Your Ref: OWPC21994
Our Ref: FG/29/19/PL 15-03-2019
Please ask for:
Mrs A Gardner

Erection of 1 No. 2 bed dwelling
South Point 1 Beehive Lane Ferring

Thank you for your internet representation made on 3rd April 2019 which has been recorded as '**an objection**' with the comments as follows:

Proposed Site Plan, Location Plan,
and Context Plan

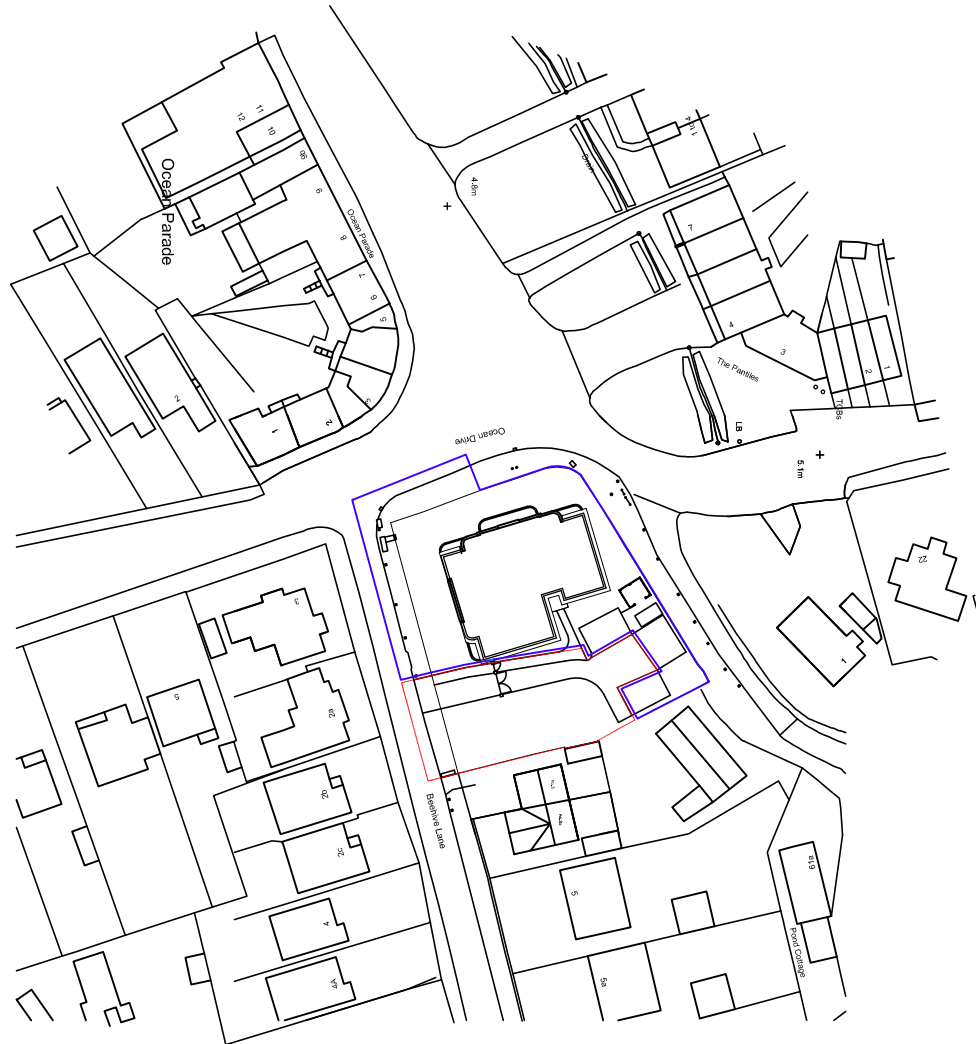
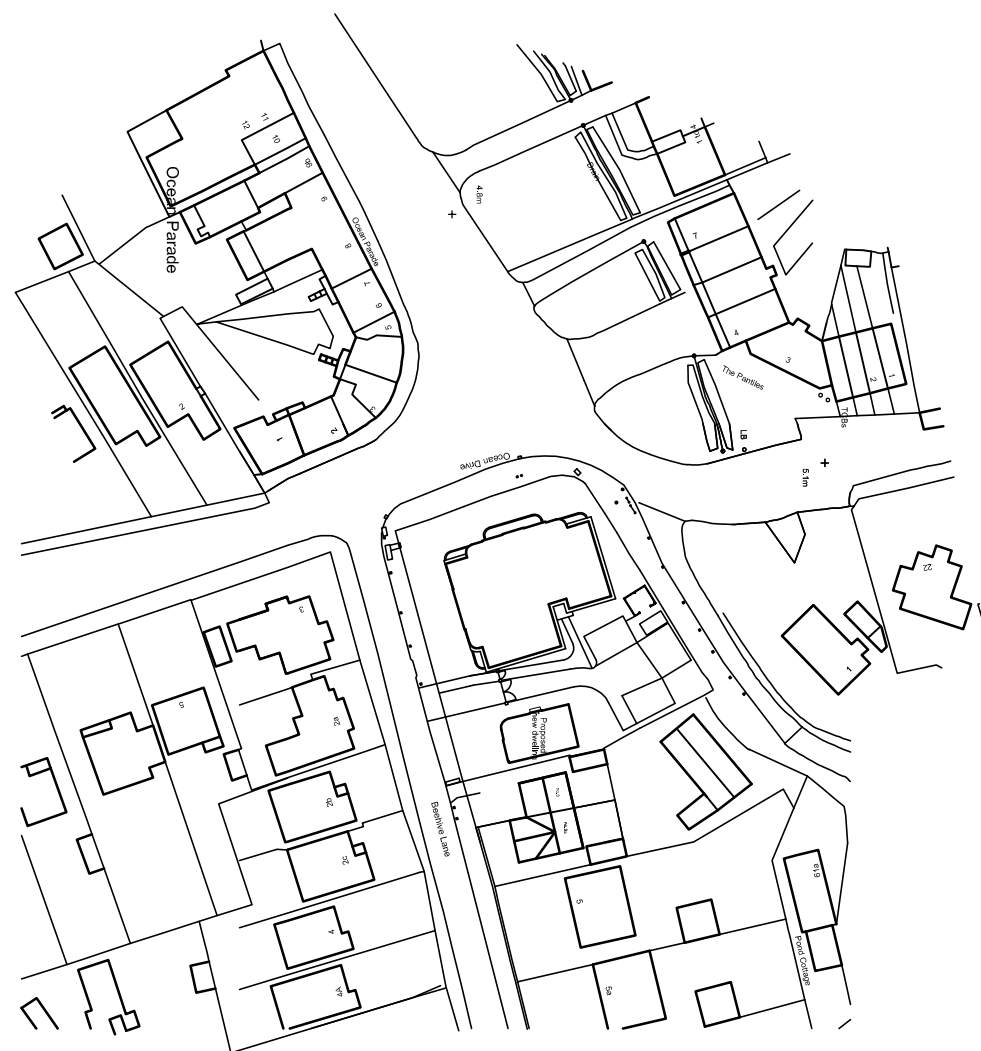
This is an overdevelopment of the site as the lawns and gardens were supposed to be for the benefit of existing owners.

There is already insufficient parking on site and the applicant has avoided the true parking capacity required by making the spaces unallocated.

No account has been taken or shown on the plans of the proximity and interference with the neighbouring bungalow in Beehive Lane.
